April 21, 2014

**Subject: 421 Warren Avenue
Preliminary Level III Site Plan Application
Response to Peer Review Comments**

We have received and reviewed Woodard & Curran's peer review comments dated March 3, 2014 and Tom Errico's comments dated March 12, 2014 regarding the Preliminary Level III Site Plan Application for the 421 Warren Avenue Commercial Complex project. We offer our responses to these comments. For ease of reference we have repeated each comment in *italics* followed by our response.

SHEET TITLE **GRAVEL WETLAND DETAILS**

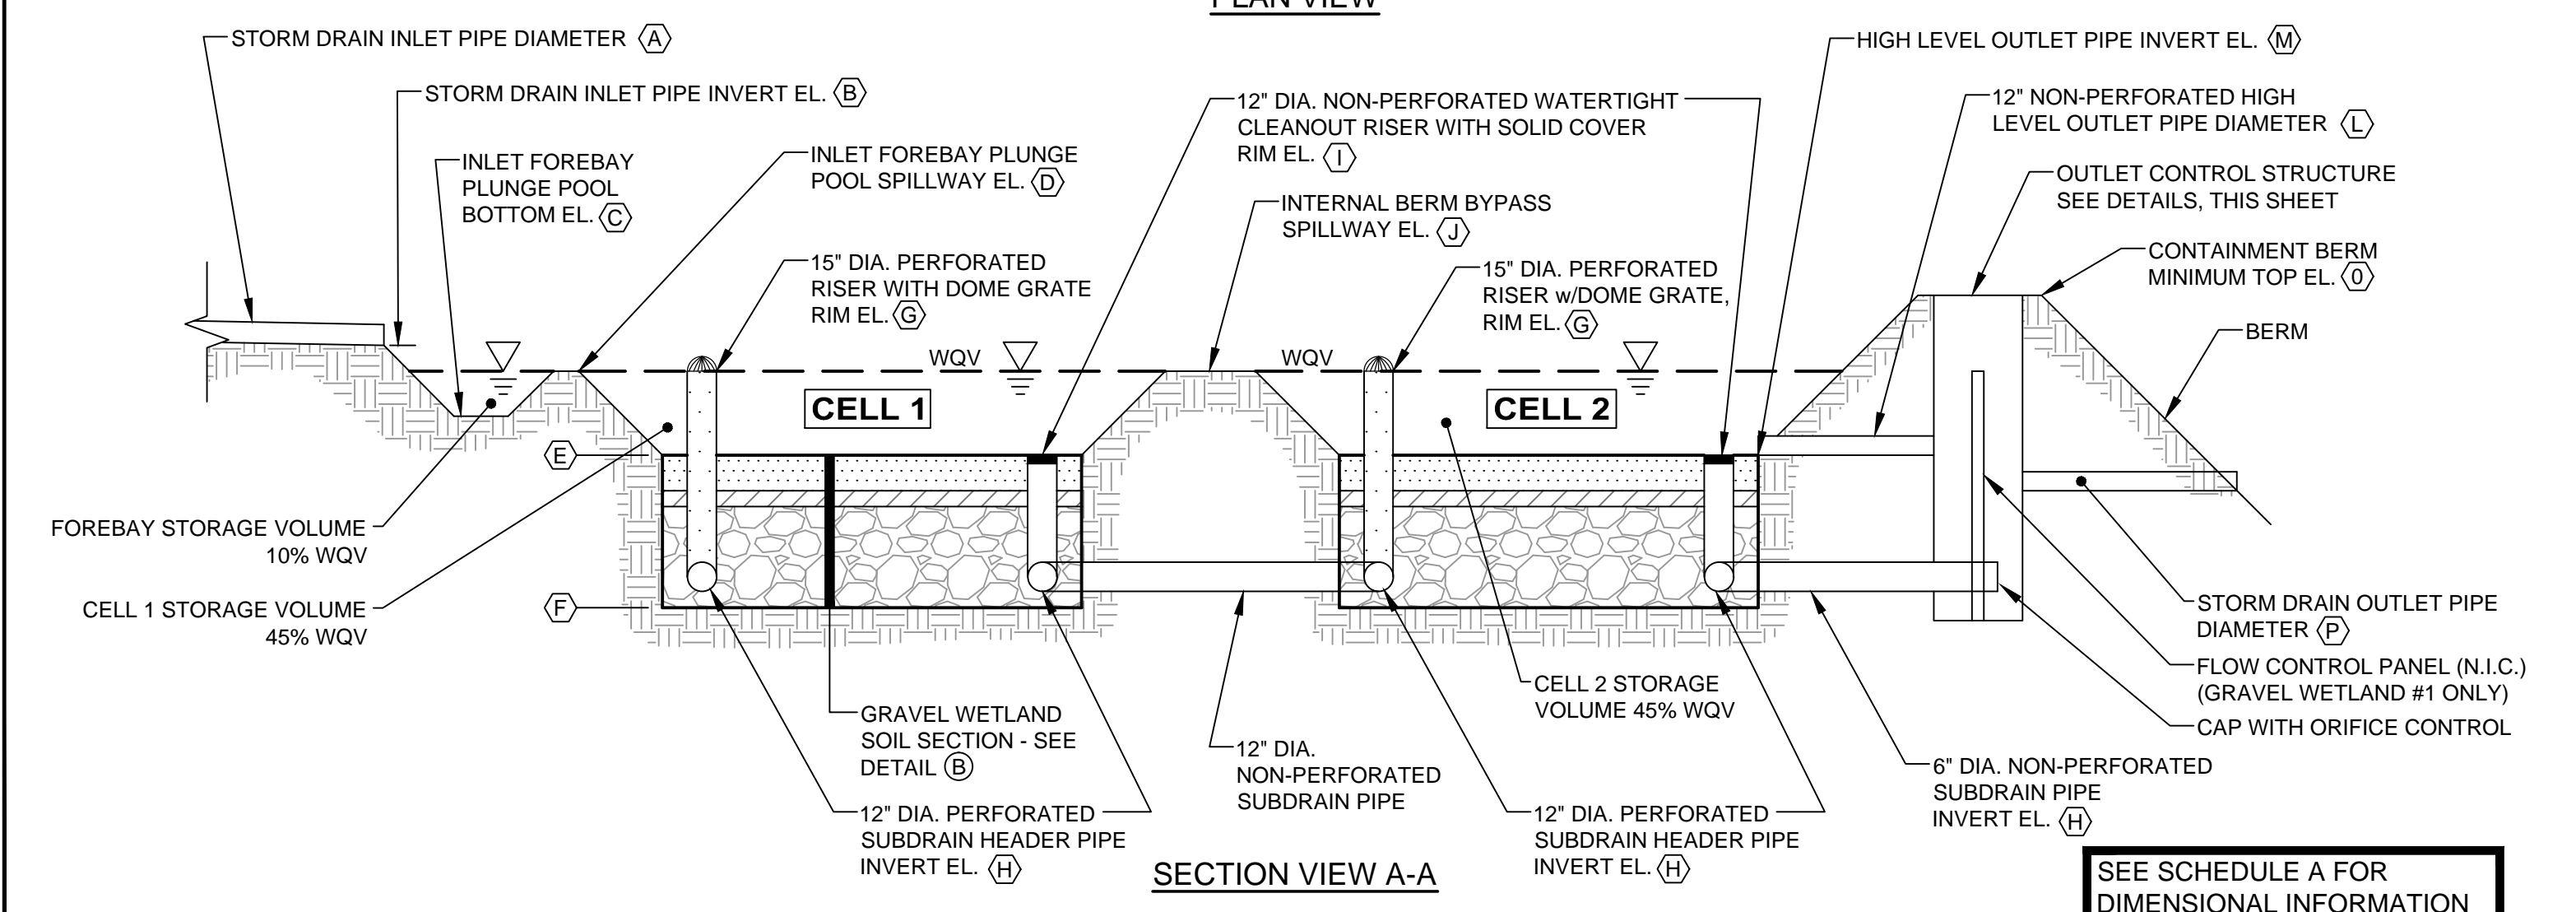
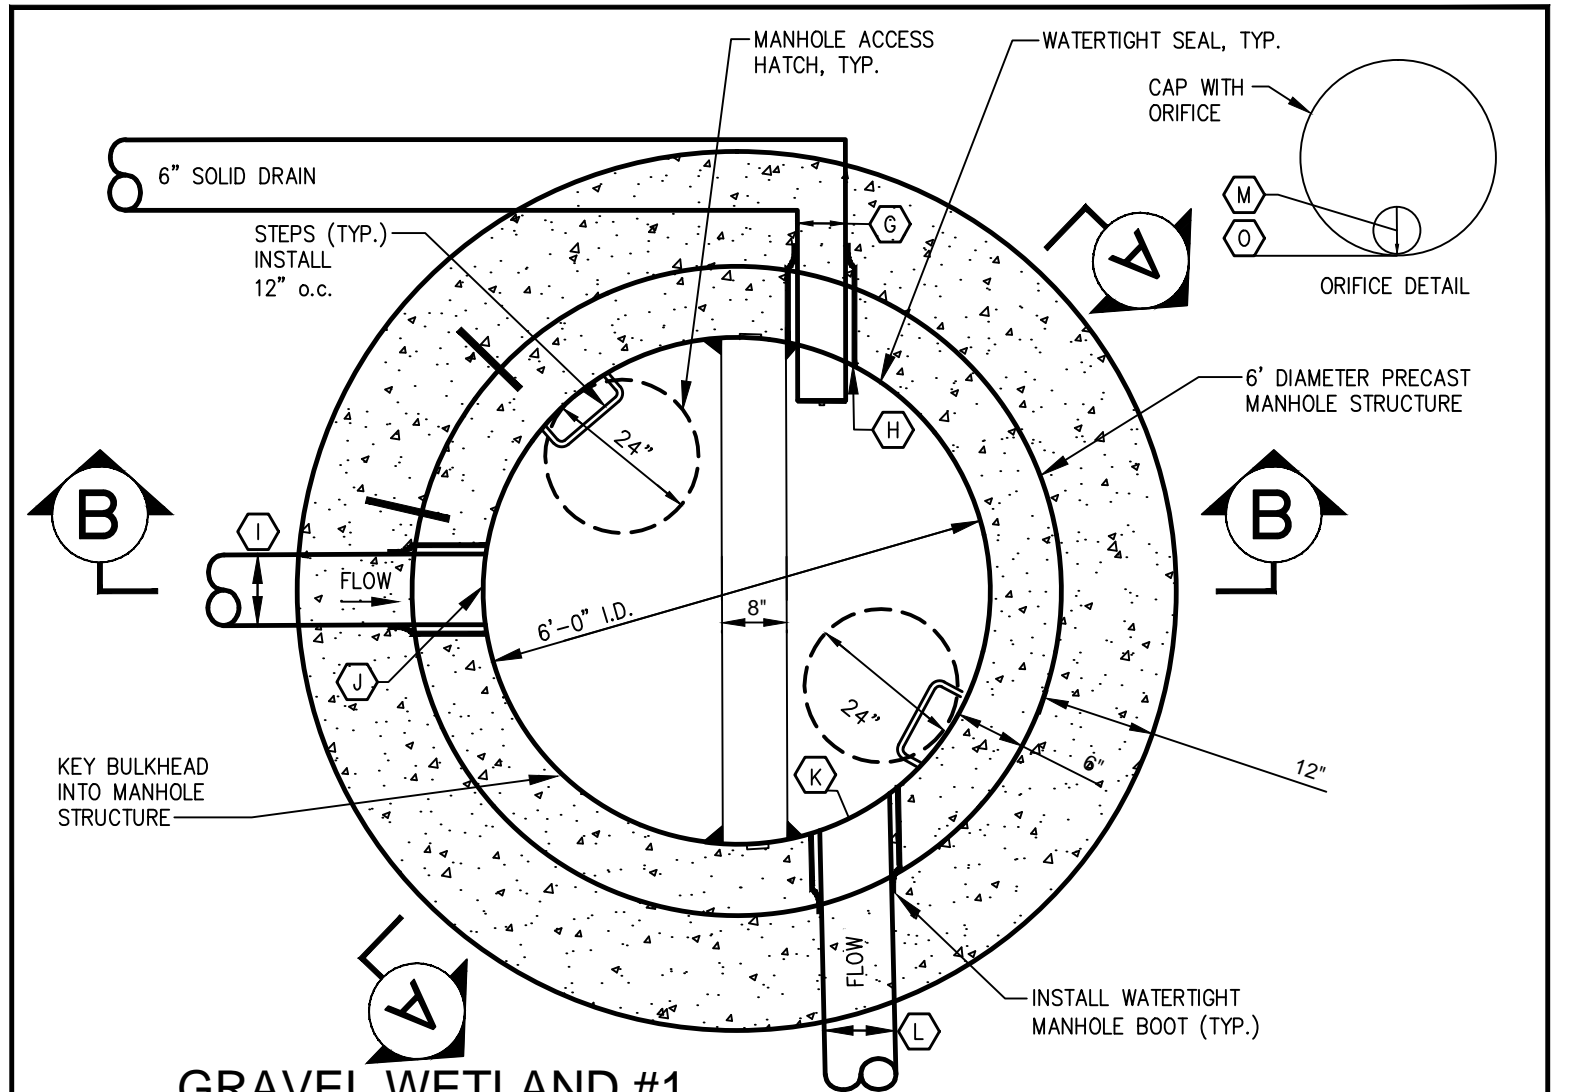
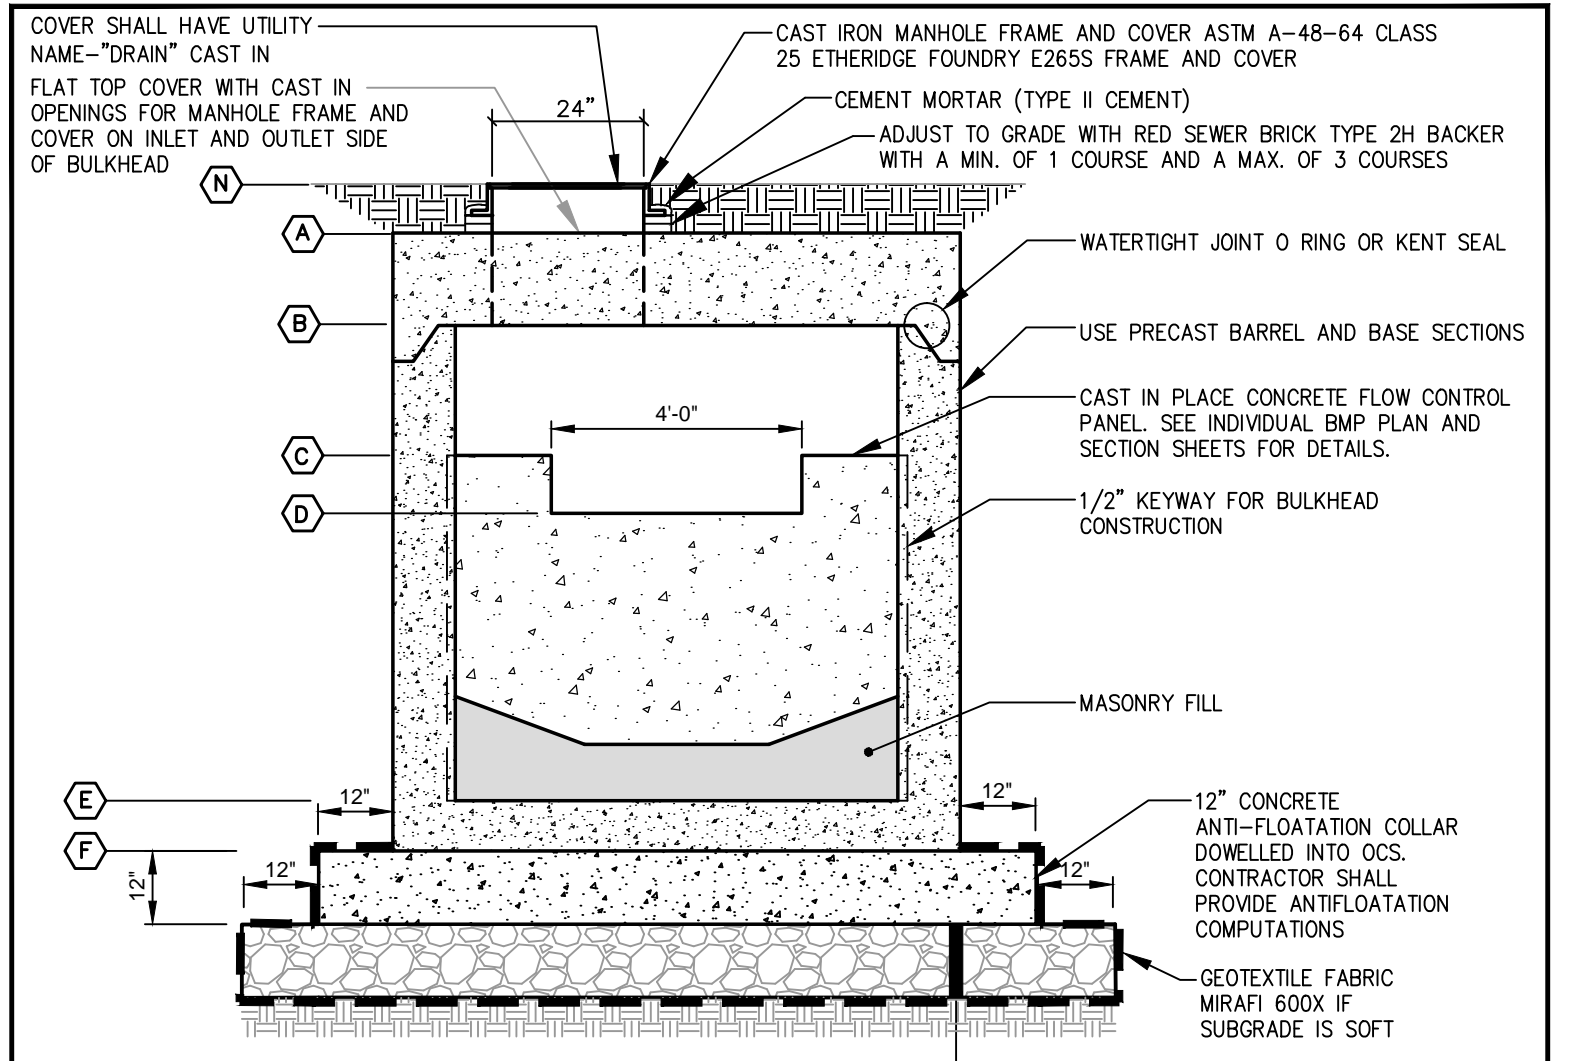
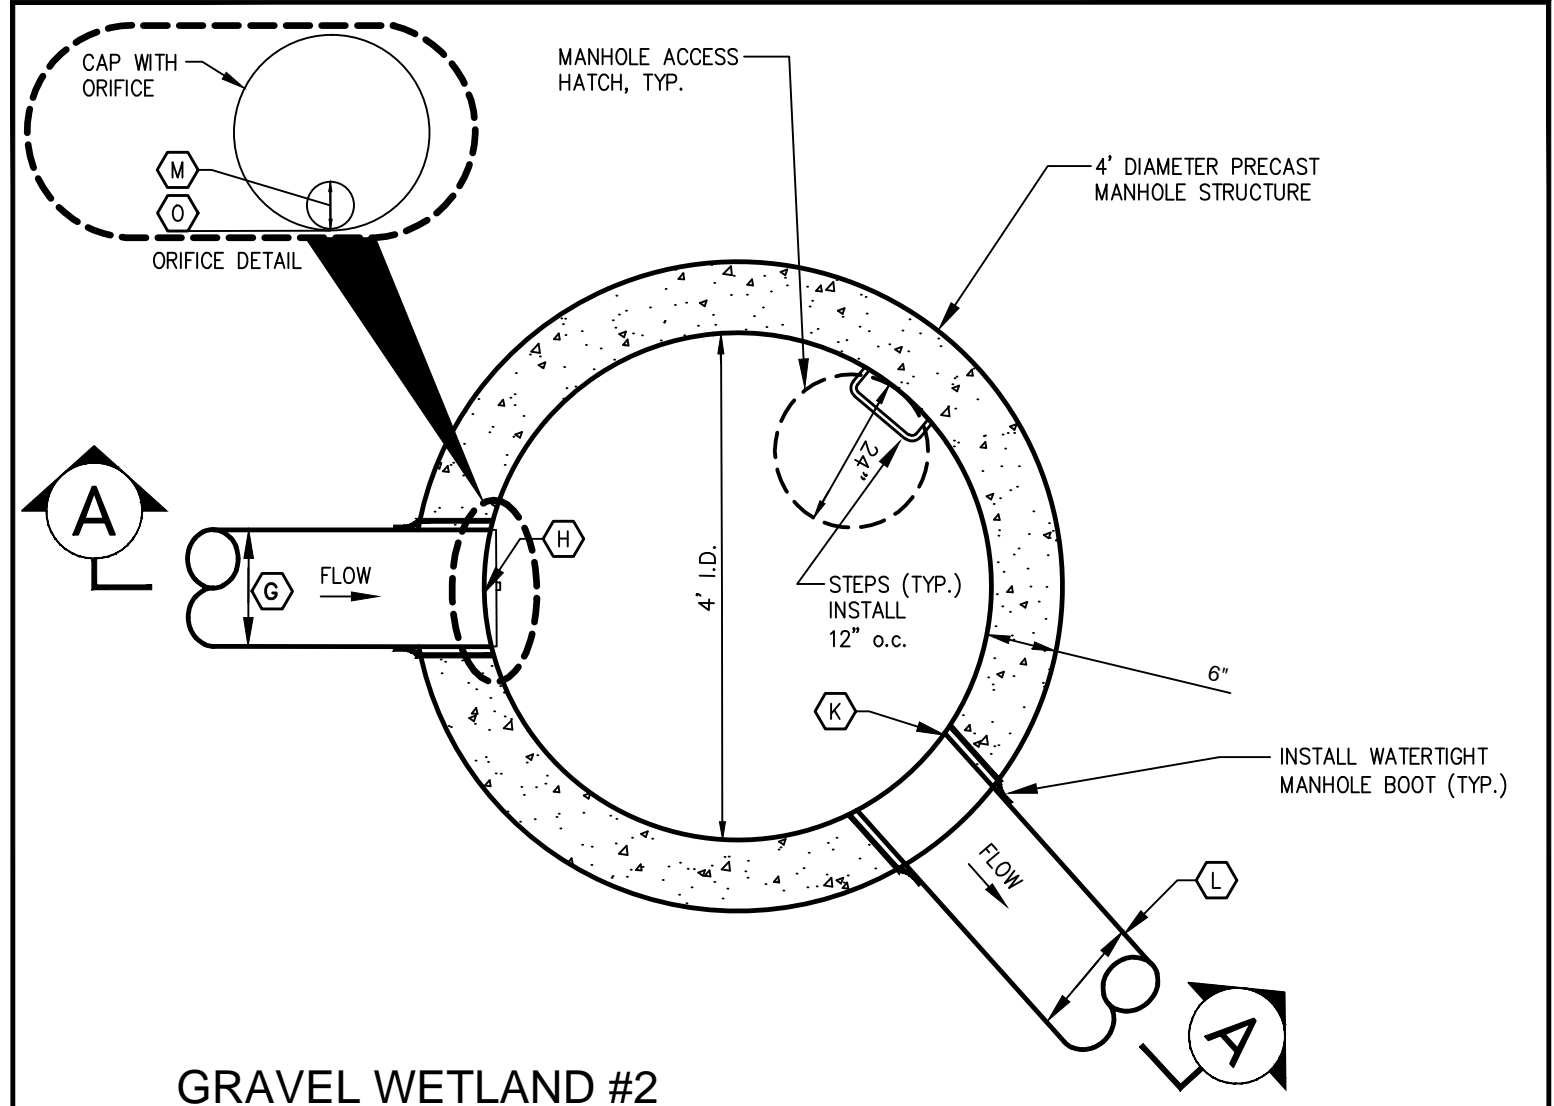
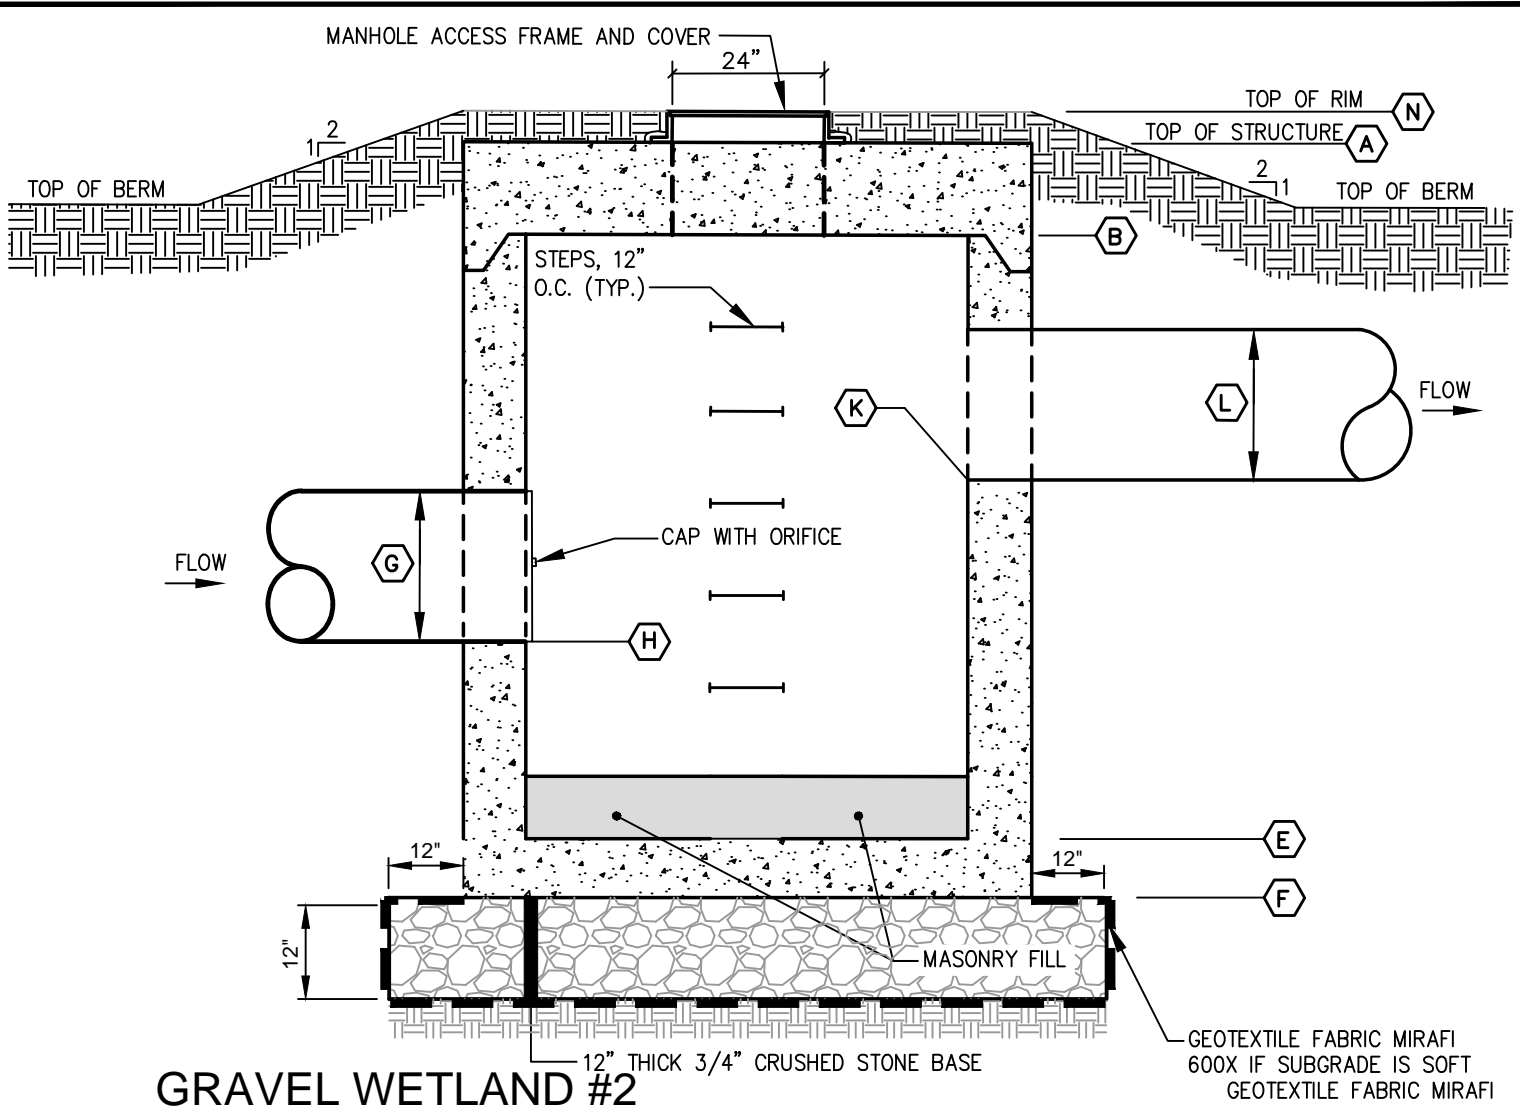
e) As noted on the plans, the Applicant intends to add outlet elevation information to the outlet control structure details for both gravel wetlands as part of the final submittal. Without this information we cannot verify the routing or model inputs for Pond 4P (GW2) or Pond 5P (GW1). When the outlet control structure elevations are incorporated into the final submittal, please revisit or provide explanation on the routing methodology for GW1 & GW2 in the HydroCAD model; we are unable to follow the routing as currently presented.

b) The Applicant has submitted drawdown calculations for sizing the gravel wetlands' outlet control structure orifice control devices; however, the orifices do not appear to be specified on the design plans/details. The Applicant should clarify with the final design package.

The Applicant has added outlet control structure to the plans and details. Refer to Sheet C-4.3, Detail E for an updated elevation schedule.

Orifice sizes and locations have been added to outlet control structure details on Sheet C-4.3. Orifice details correspond to drawdown computations submitted in Appendix E.
